# CITY OF ALBUQUERQUE

April 14, 2022

**RE: Champion Xpress Car Wash  
9640 Universe Blvd. NW  
Grading and Drainage Plan  
Engineer's Stamp Date: 03/25/22  
Hydrology File: B10D003J**

Based upon the information provided in your submittal received 03/25/2022, the Grading & Drainage Plan is **not** approved for Building Permit. The following comments need to be addressed for approval of the above referenced project:

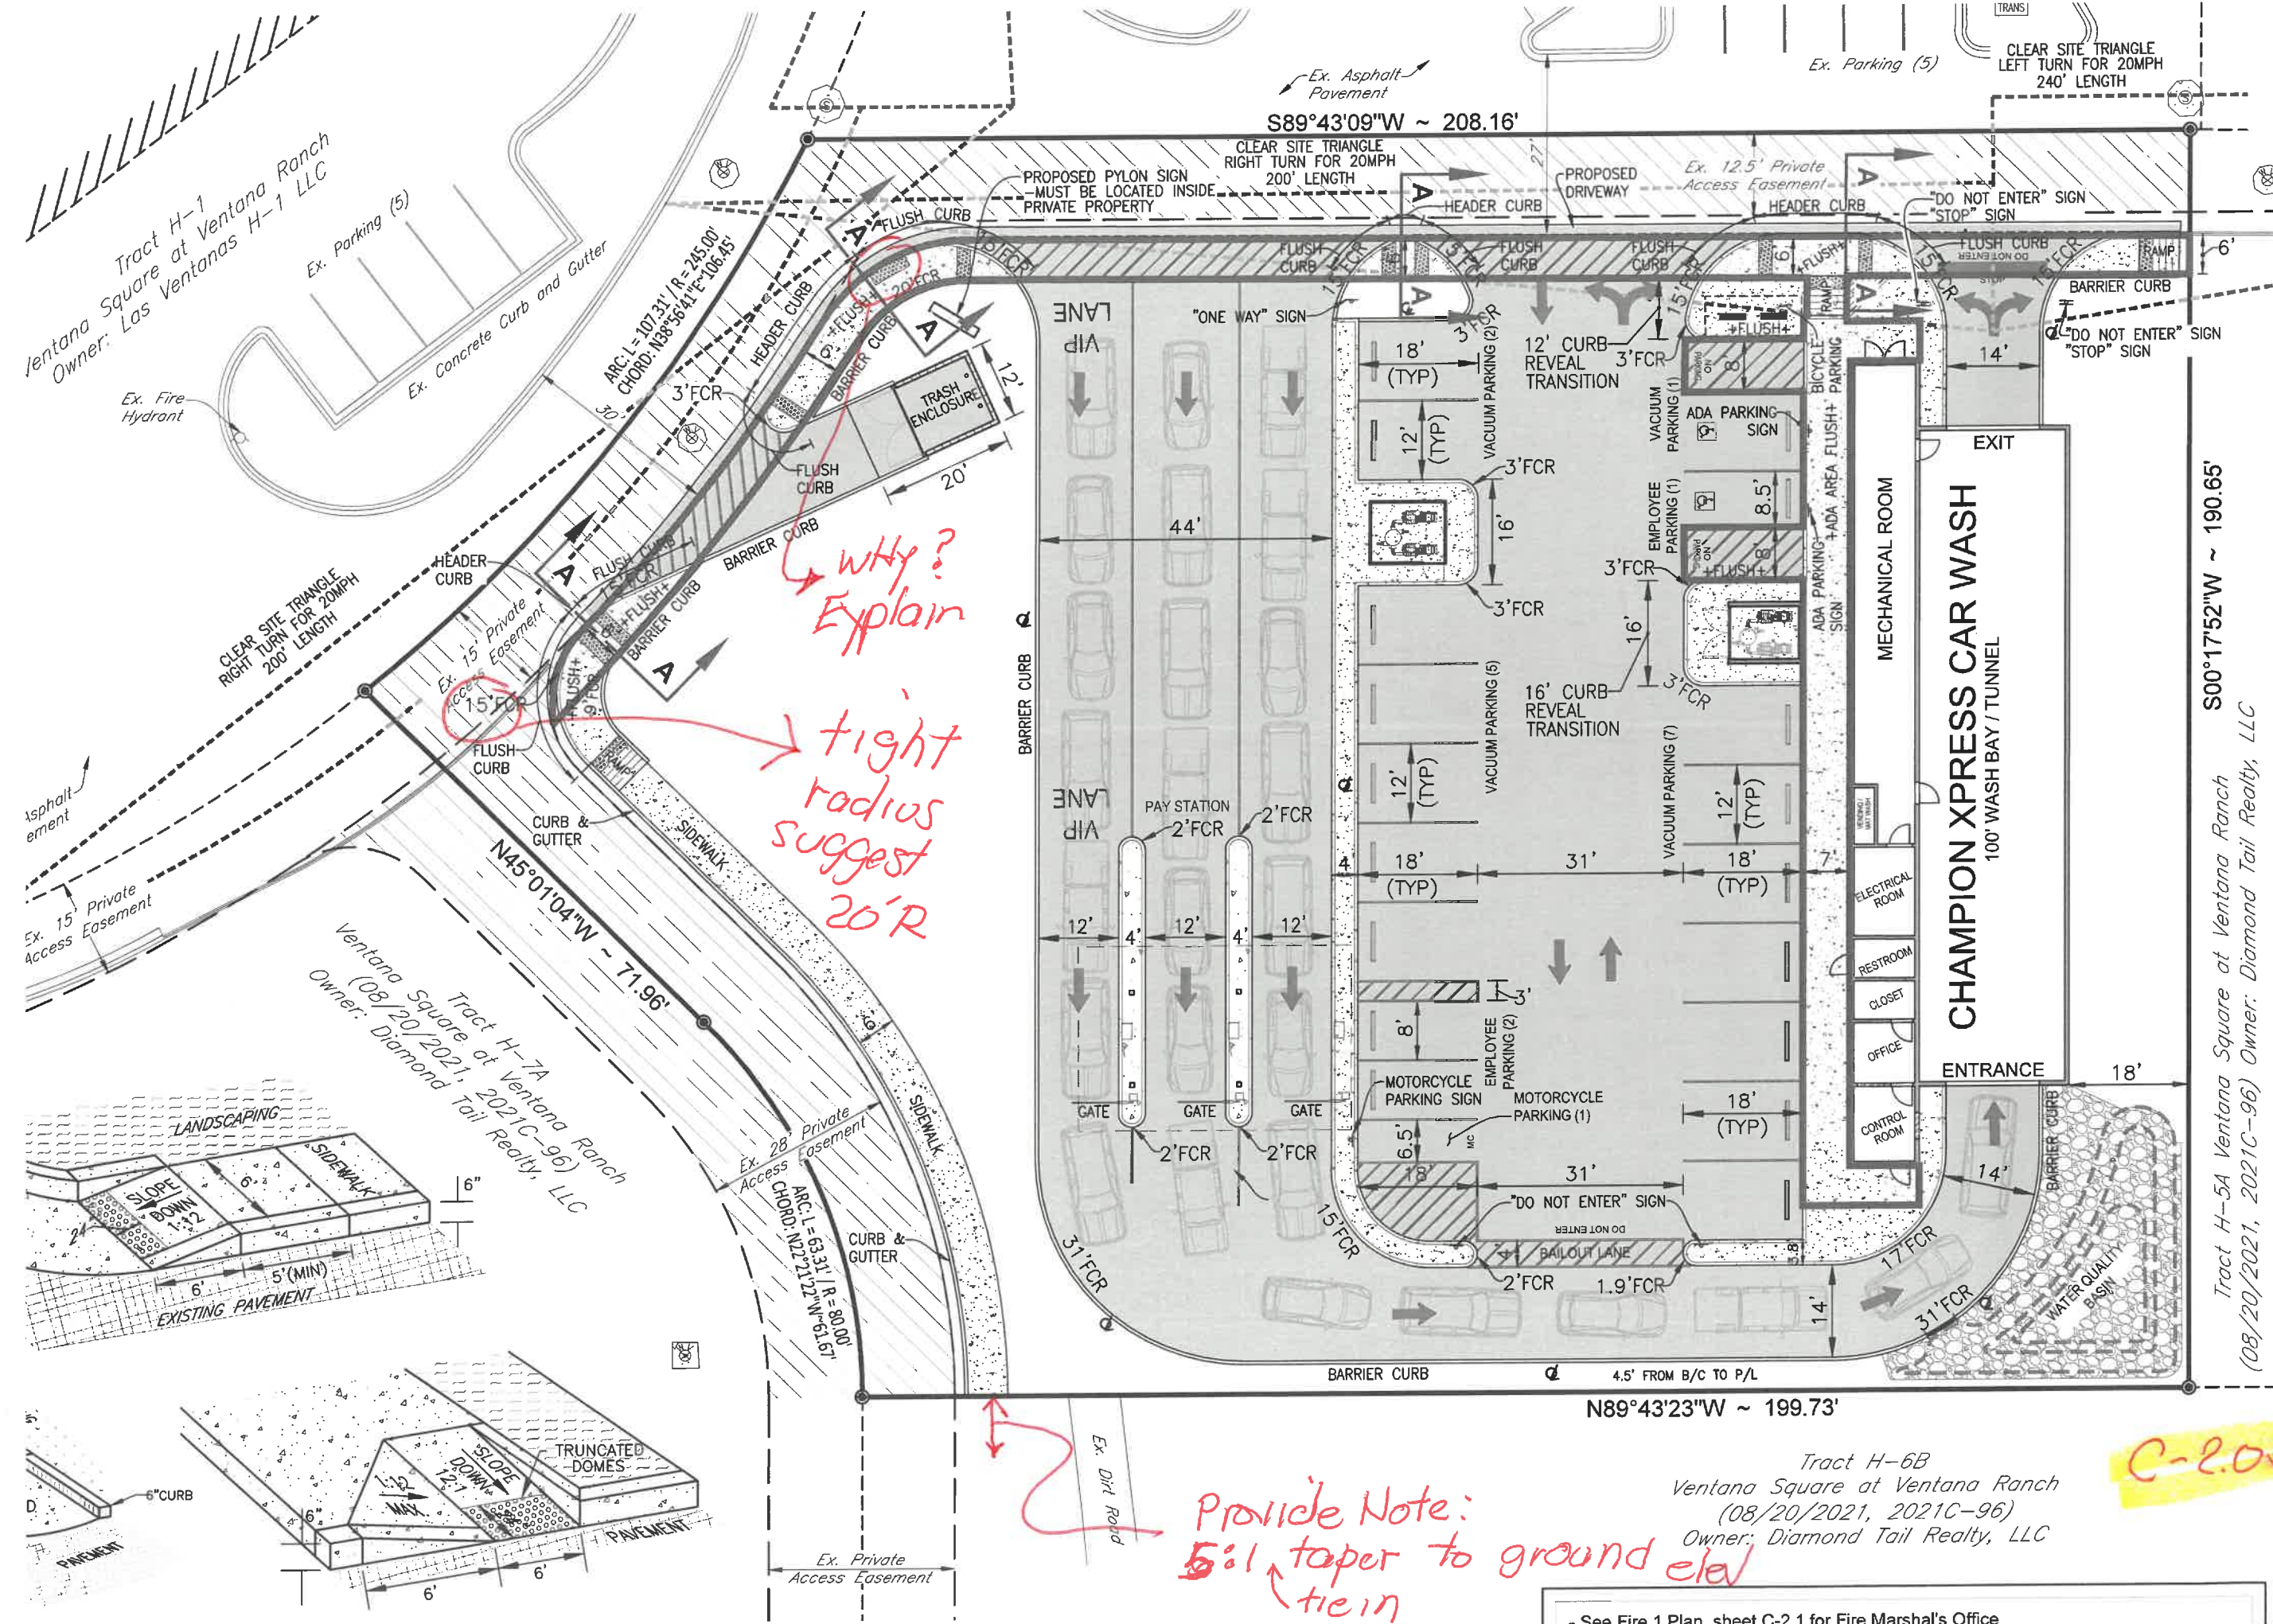
1. Please provide the Benchmark information (location, description and elevation) for the survey contour information provided.
2. Please use the procedure for 40 acre and smaller basins as outlined in Development Process Manual (DPM) (signed 06/08/20) Article 6-2(a). Please provide both the existing conditions and proposed conditions for the 100 year-6 hour storm event. Under the proposed conditions, please mention the overall Master Drainage Plan for Ventana Square Subdivision by Thompson Engineering dated 12/23/20 and the allowable discharge for this site as 3.51 cfs.

3. Provide management onsite for the Stormwater Quality Volume (SWQV) in accordance with the new drainage ordinance, § 14-5-2-6 (H) enacted 10/2/18 (Council Bill C/S O-18-2). Please show the top and bottom of the ponds along with the volume for each pond. The onsite drainage should be directed to these ponds prior to being collected in a private

unground drainage system. Please follow the DPM Article 6-12 Stormwater Quality and Low-Impact Development for the sizing calculations. To calculate the required SWQV, multiply the impervious area draining to the BMP by 0.42 inches for new development sites. The calculations of both the required and the provided volume of each BMP must be shown on the Grading and Drainage Plan. Each BMP should be labeled on the Grading and Drainage Plan with the required SWQV and associated water surface elevation and the 100-year water surface elevation. Landscaping of surface BMPs is also required to be noted on the Grading and Drainage Plan.

4. Please show the proposed access road for Ventana Square Subdivision (built under CPN # 670982. Also, please show and label the 20' Waterline Easement. Please note that the curbing and sidewalk along this access road is to be built during Building Permit with these plans which needs to be shown and called out.
